Please upload the below to the above application; Proposed Elevations- further information.

Condition 3 – materials;

Proposed East Elevation 1:50

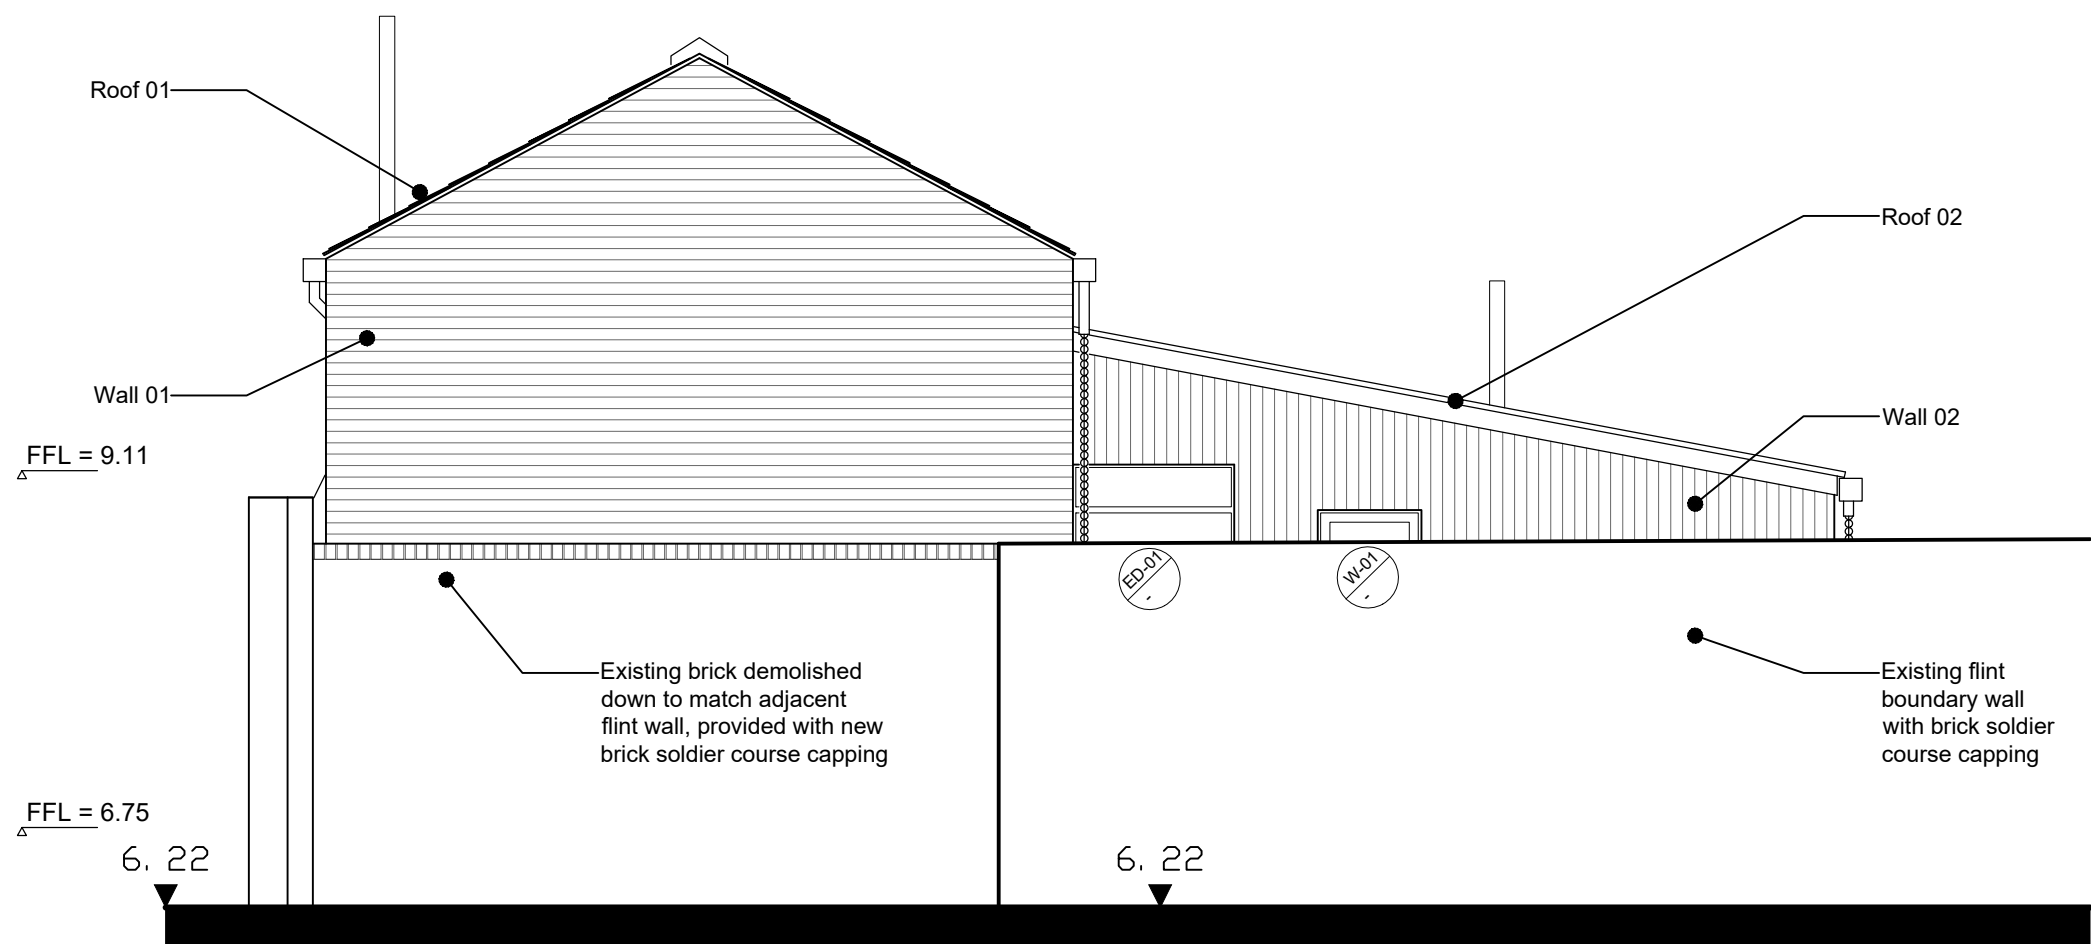
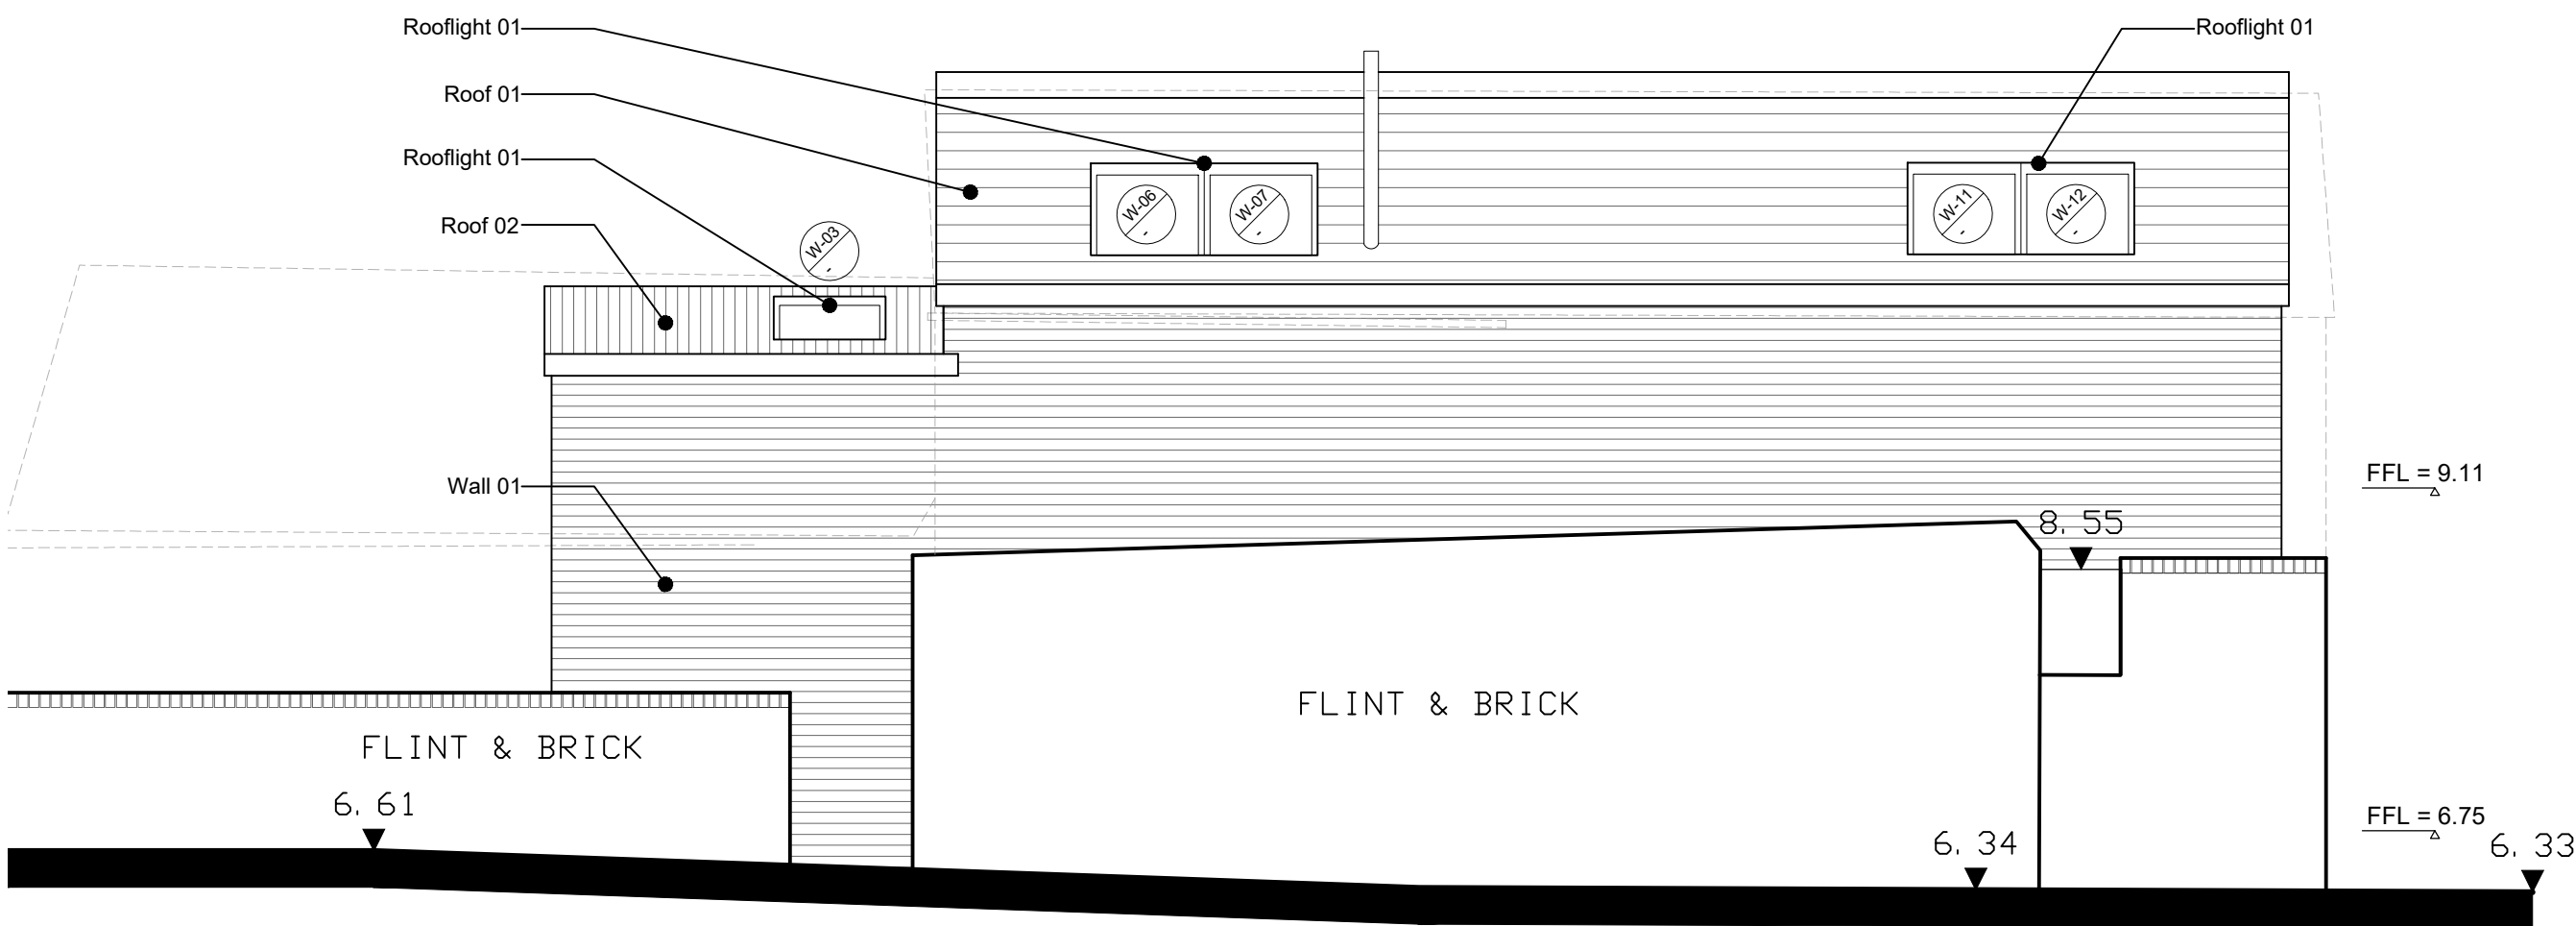
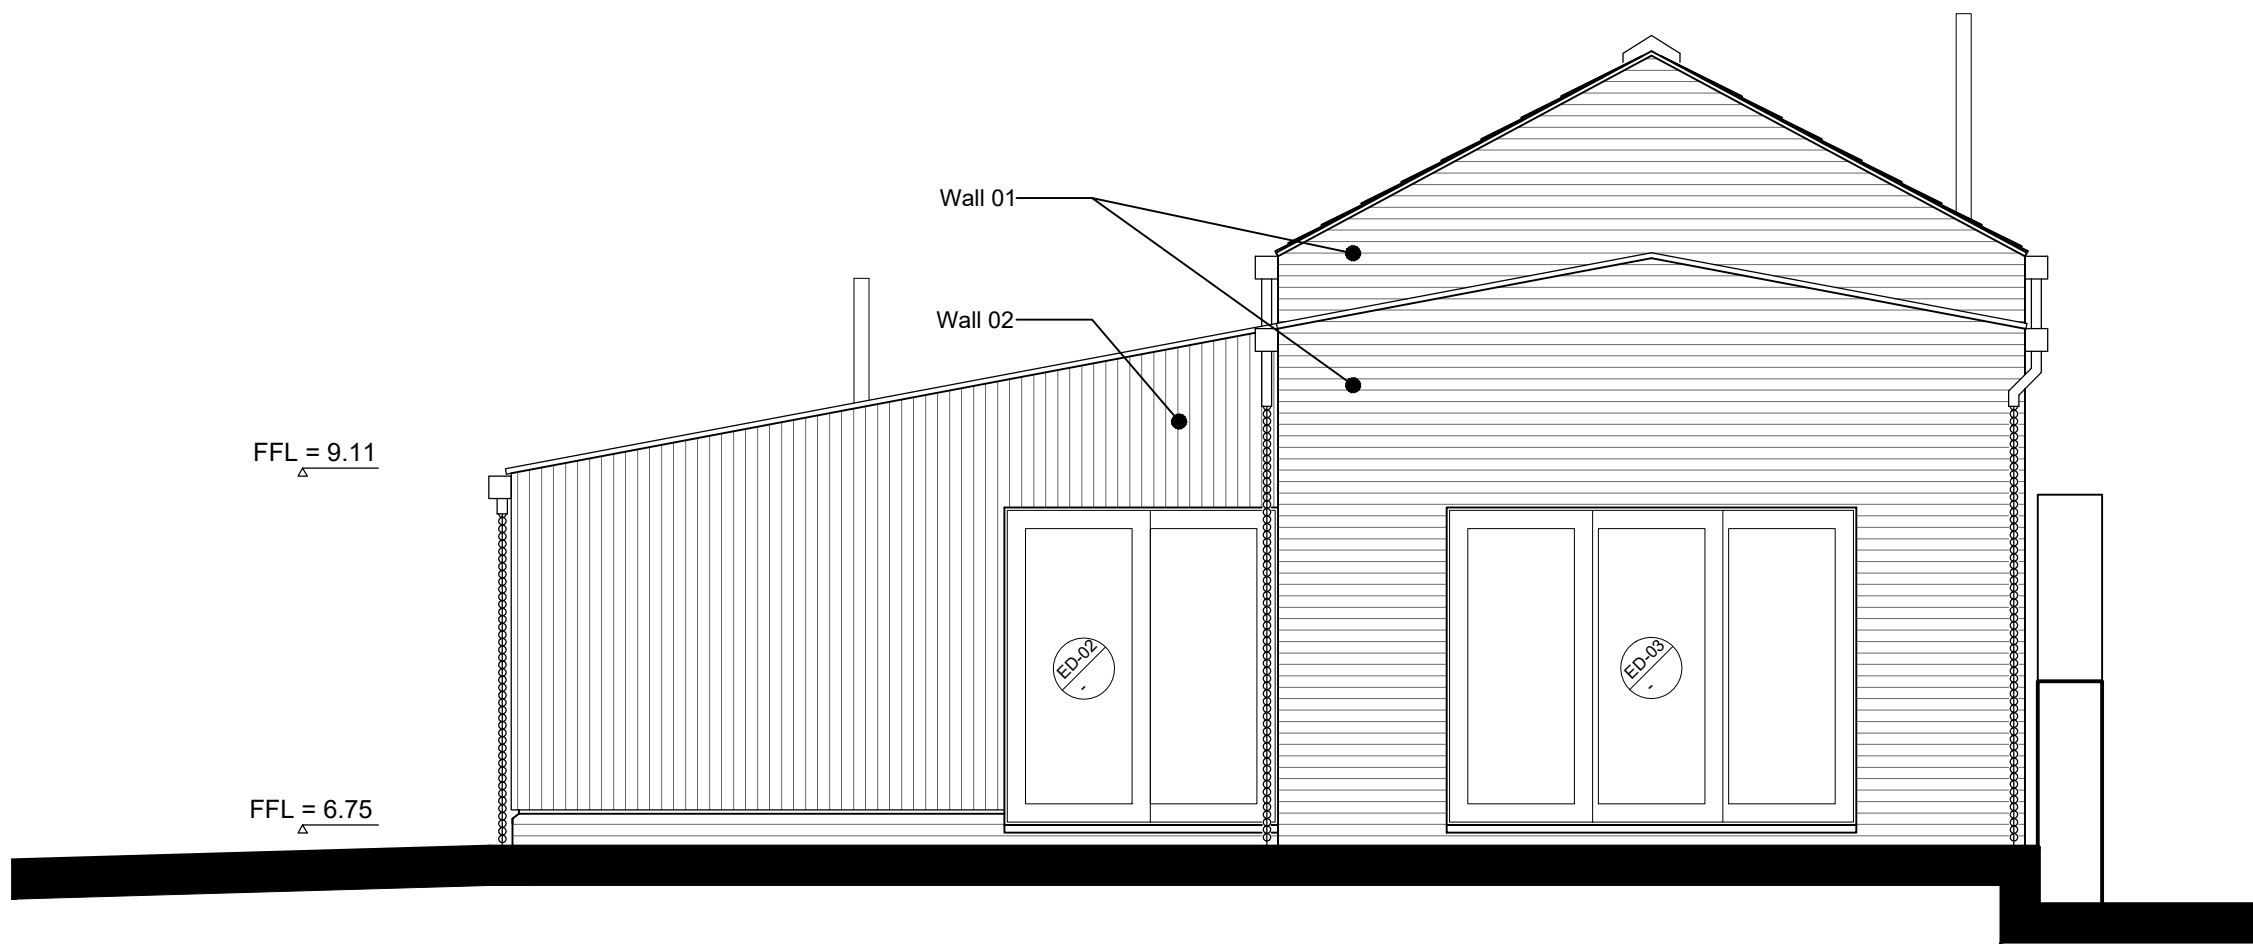
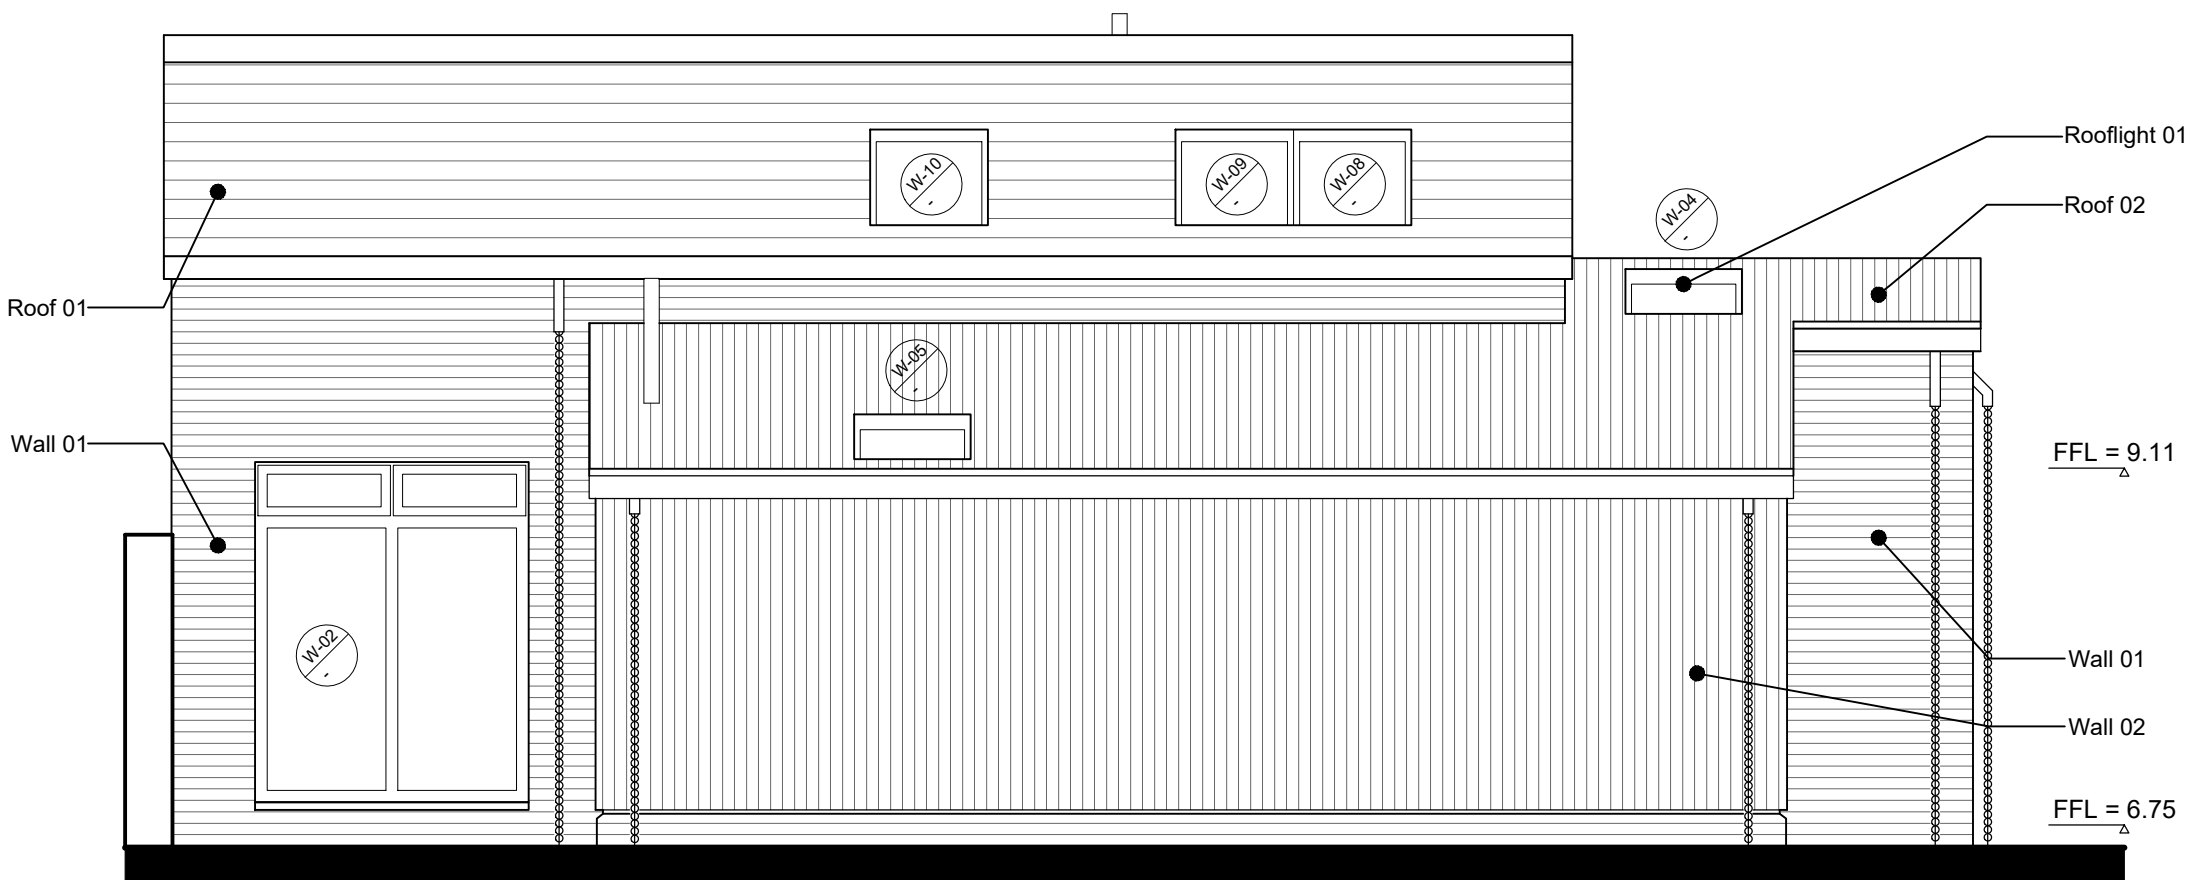
You have provided 'Materials Schedule'

However it would be useful if you provide the drawing as well showing Wall 01, Wall 01
Roof 01, Roof 02.

Certainly, please find attached revised proposed elevations with the labels included.
